App No: M/32/19/PL

Proposal: New dwelling & separate garage replacing the proposed new house in the previous planning permission ref: M/7/16/PL - Amendment to M/153/18/PL

Address: 46 Sea Lane Middleton-On-Sea PO22 7RX

**Proposed Landscaping
and Car Parking
1:250**

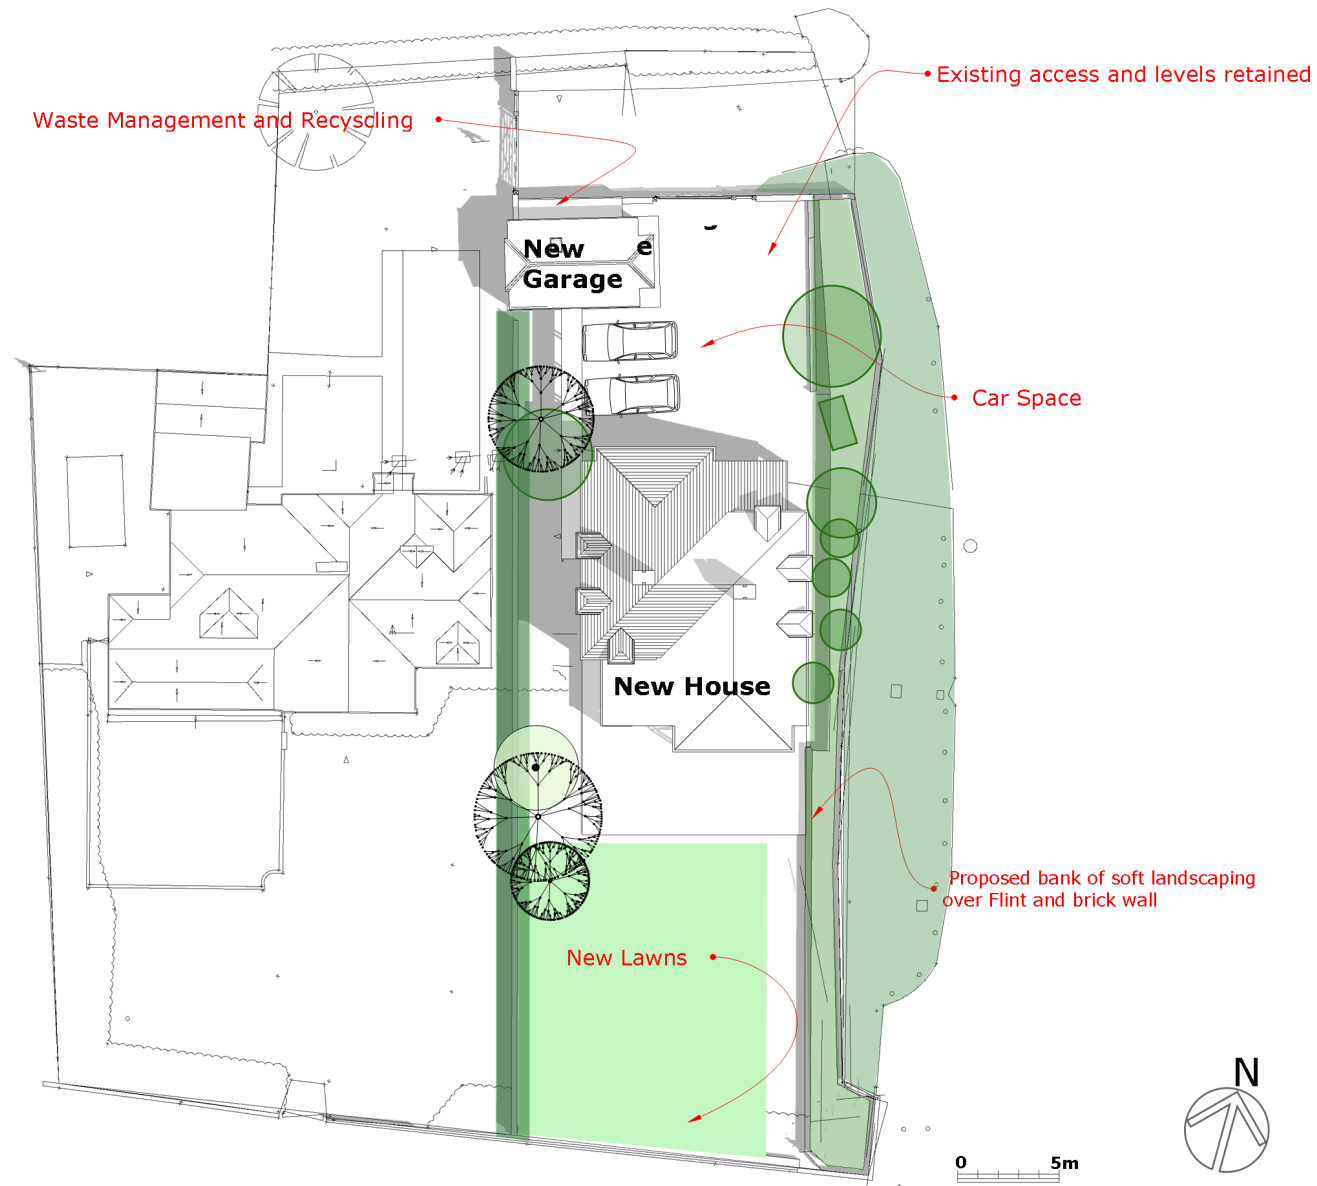
We require a number of enhancements are incorporated within the scheme and shown with the landscaping strategy. These include;

- Any trees removed should be replace at a ratio of 2:1
- Wildflower meadow planting used
- Filling any gaps in tree lines or hedgerows with native species
- Bat and bird boxes installed on the site as detailed above
- We require that gaps are included at the bottom of the fences to allow movement of small mammals across the site
- two hedgehog nesting boxes included on the site
